Addendum No. 2

RE: Contract ID C202599

Pasquotank, Camden Counties (U-4438)

US-158 From US-17B (N. Road Street) to East of Pasquotank River in Elizabeth City

SYMBOL AND PAVEMENT MARKING LEGEND

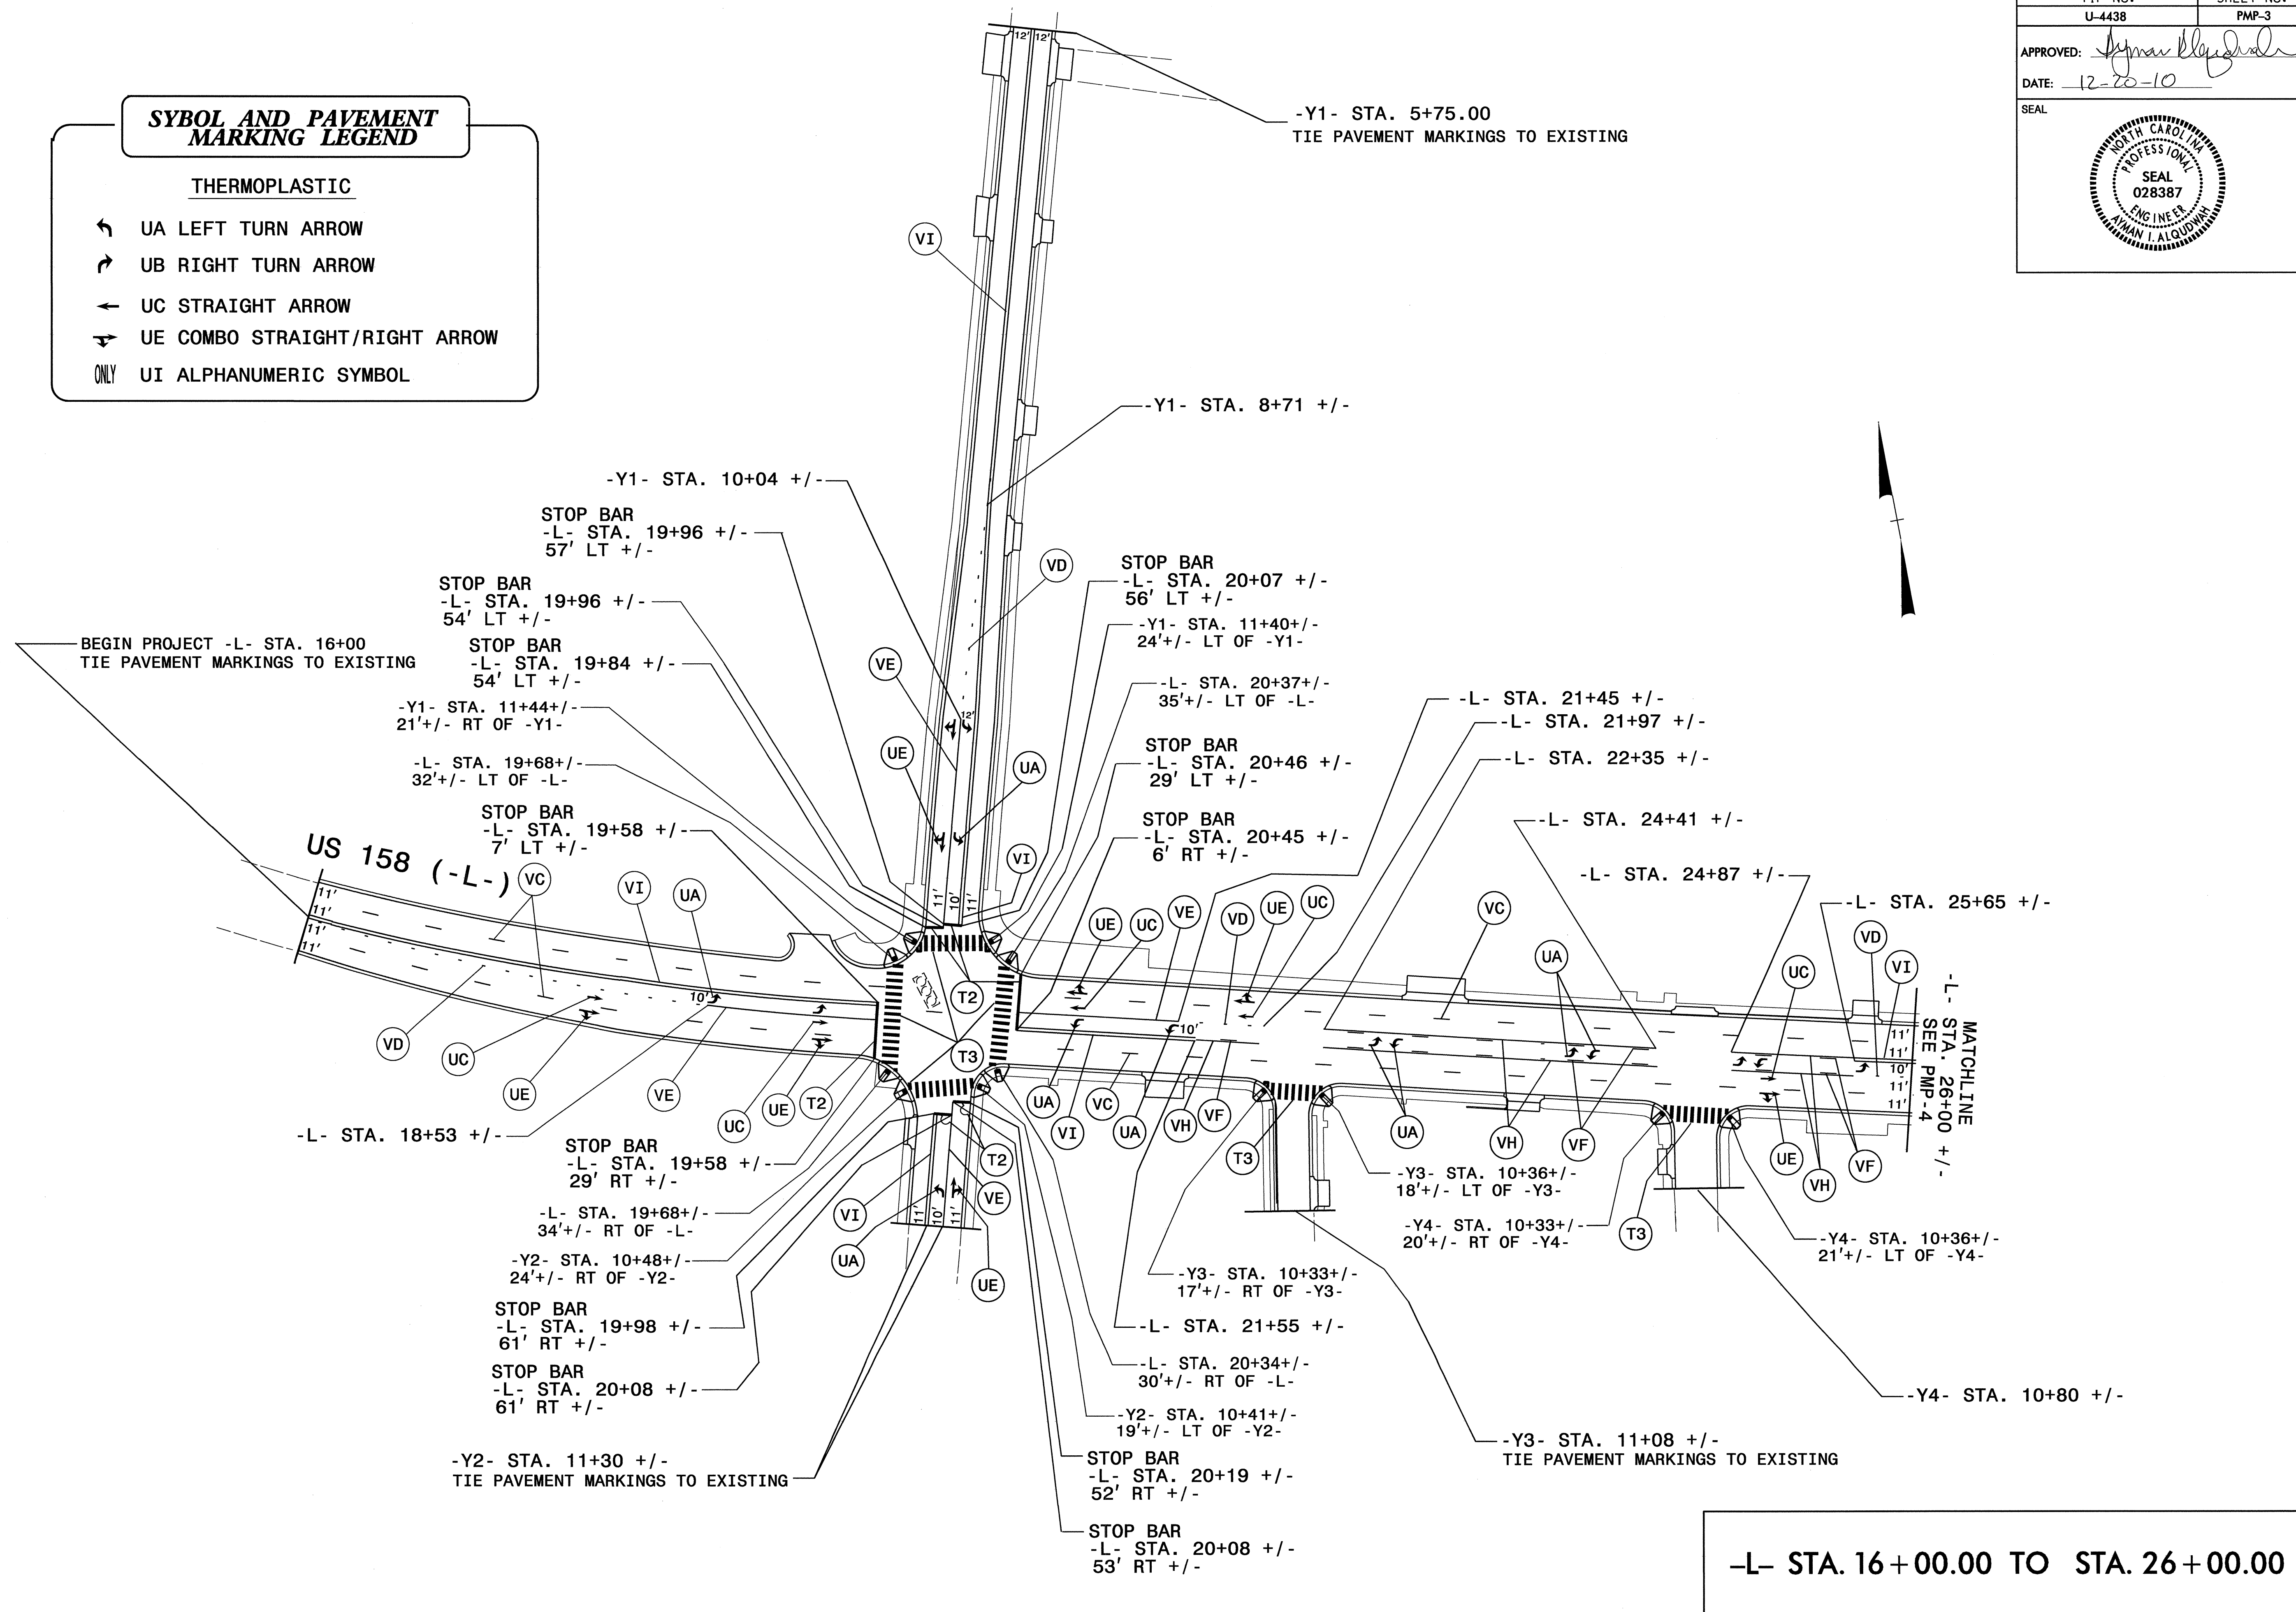
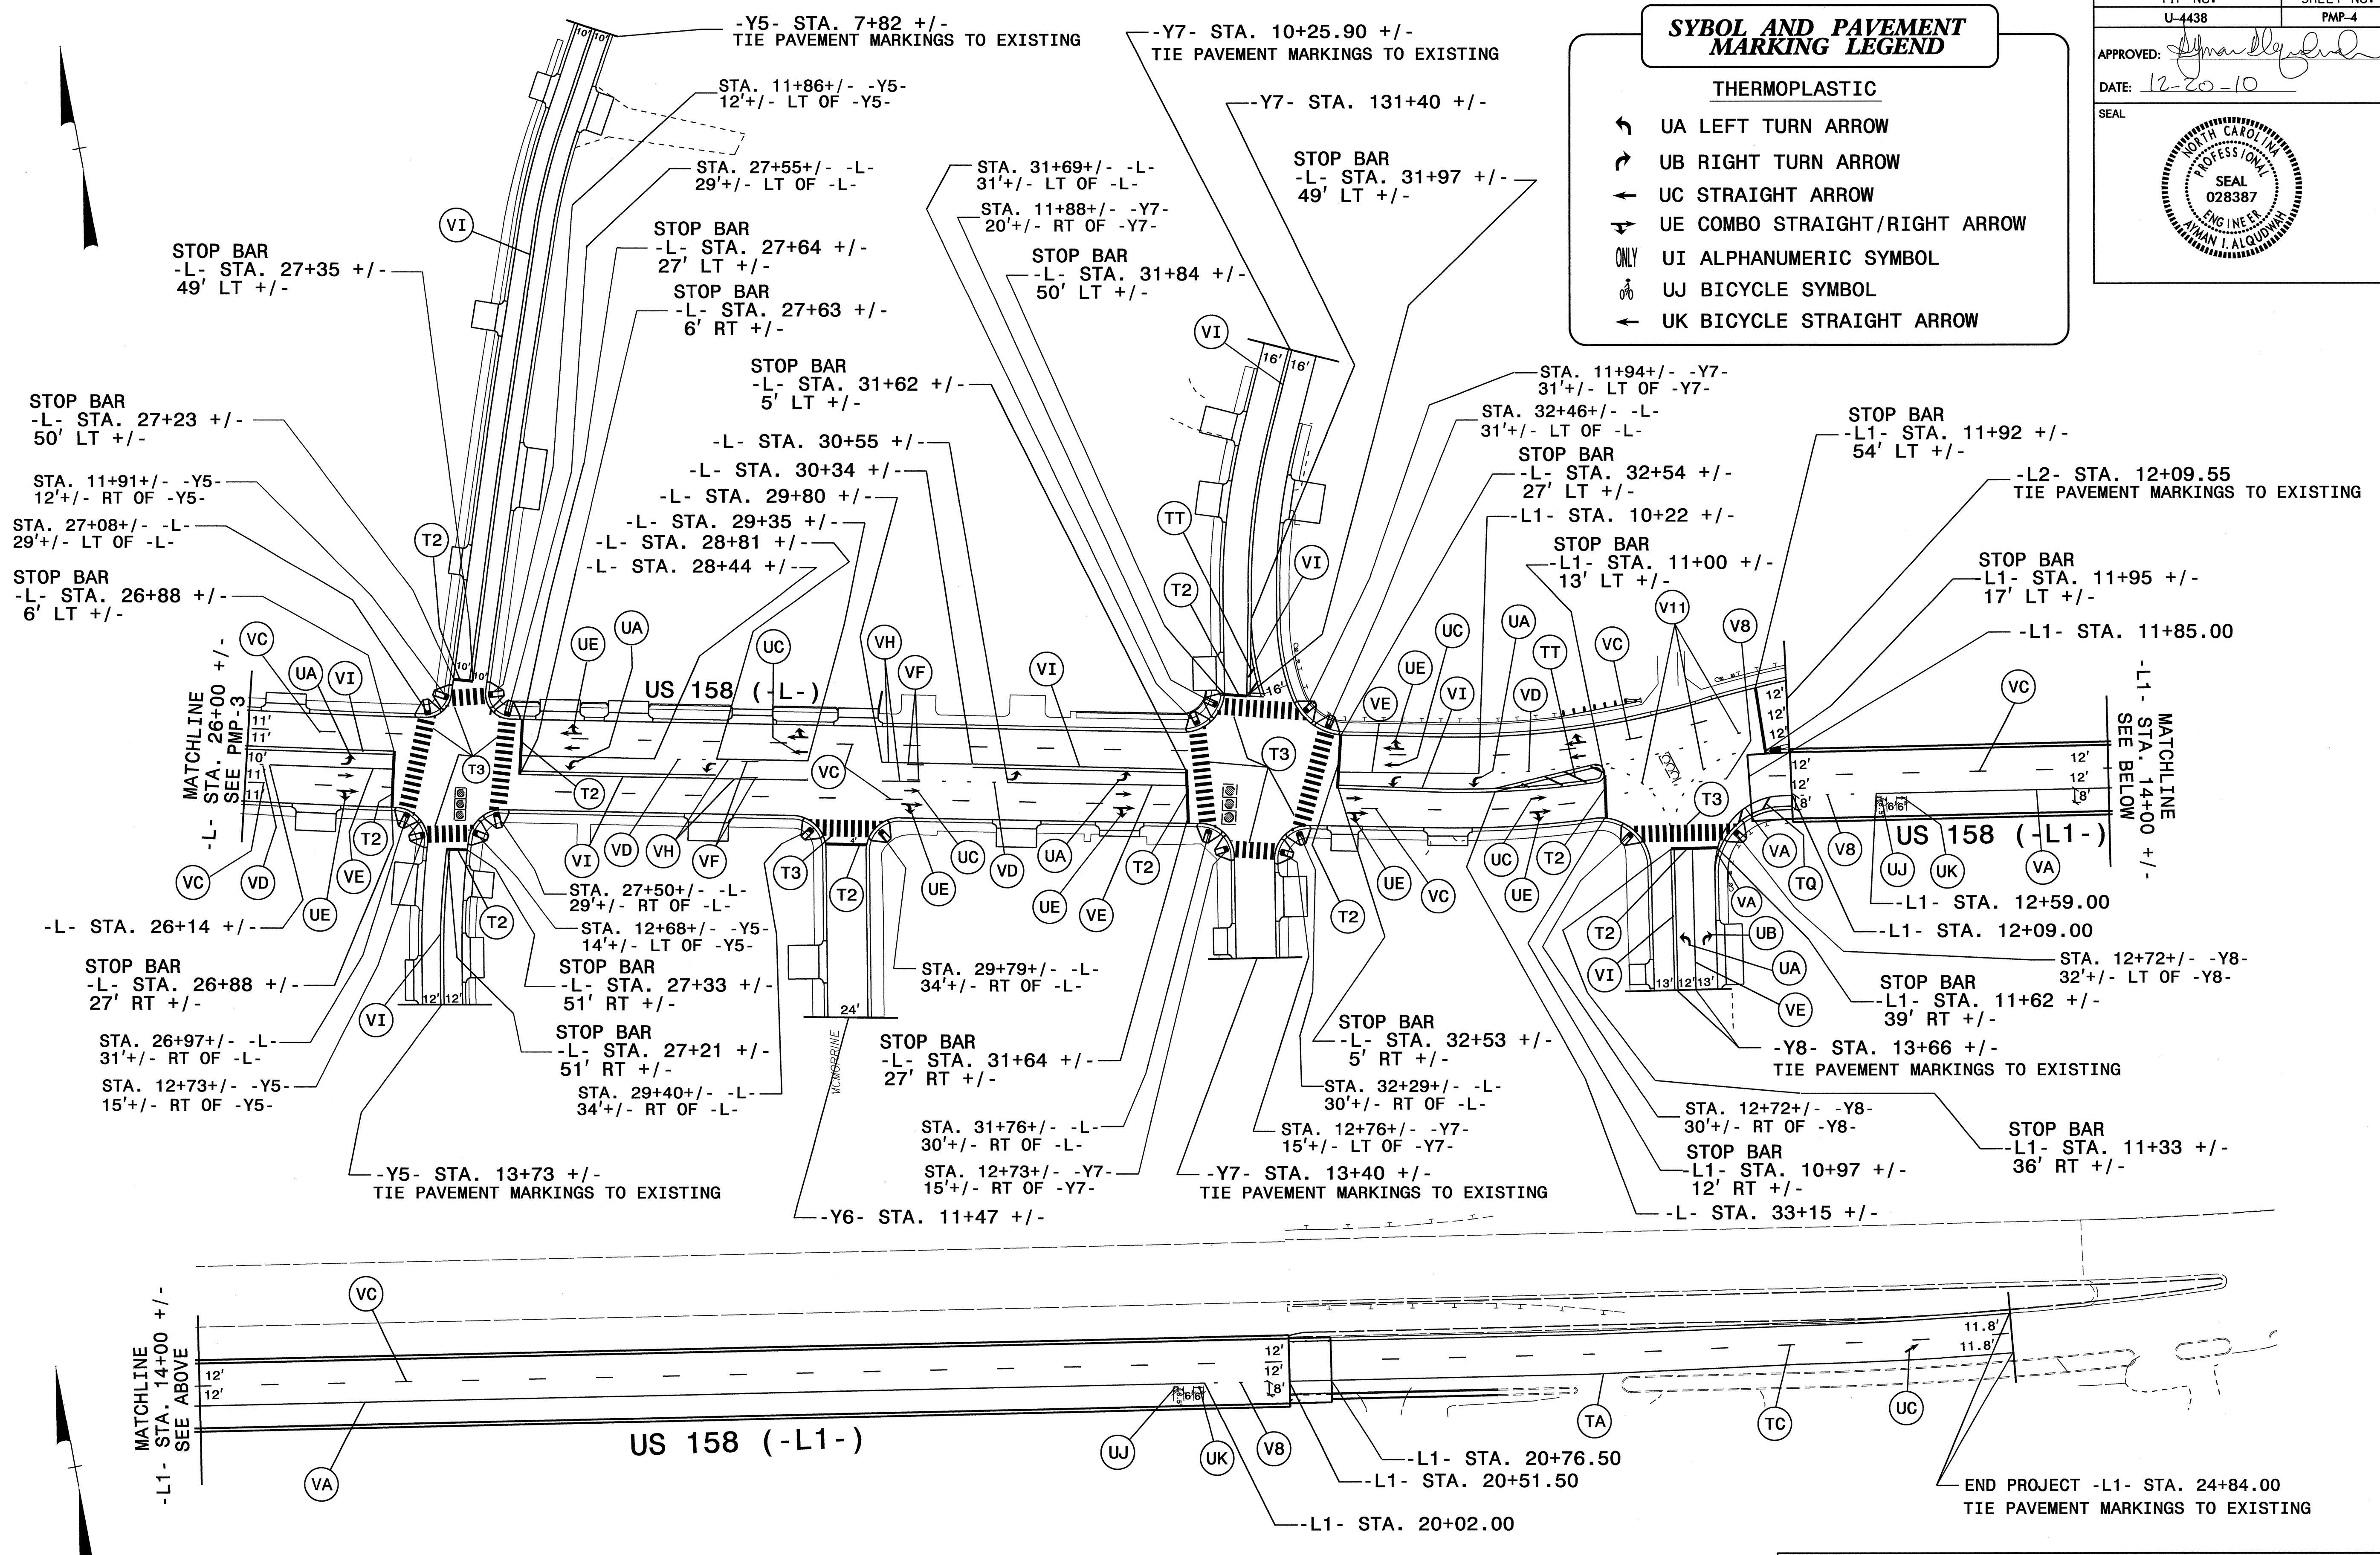
S-292:	Removed door specification (Moved to S-121)
S-361:	Corrected call-out for stairway handrail to be FRP handrail (Detail 3)
S-364:	Corrected slab and handrail call-out for Detail "Operators Room Slab Plan"
S-365:	Revised Note concerning aluminum pipe rail in Detail Section 6-6, See Sheet S-361 for pipe rail details
S-372:	Revised power cylinder type
S-377:	Air Buffer rehab is no longer a part of this contract, Detail removed
S-380:	Revised center span lock assembly detail
S-382:	Added door number designations
S-444:	Added door number designations
S-448:	Revised Total Bill of Material to change two Polyurea Pavement Marking pay items to Thermoplastic Pavement Markings

<u>Item</u>	<u>Description</u>	<u>Old Quantity</u>	<u>New Quantity</u>
135-4710000000-E-1205	Thermoplastic Pavement Marking Lines (24", 120 MILS)	2,089 LF	2,125 LF
133-4725000000-E-1205	Thermoplastic Pavement Marking Symbol (90 MILS)	59 EA	68 EA
149-4847140000-E-1205	Polyurea Pavement Marking Lines (24" Highly Reflective Elements)	36 LF	DELETED
150-4847220000-N-1205	Polyurea Pavement Marking Symbol (Highly Reflective Elements)	9 EA	DELETED
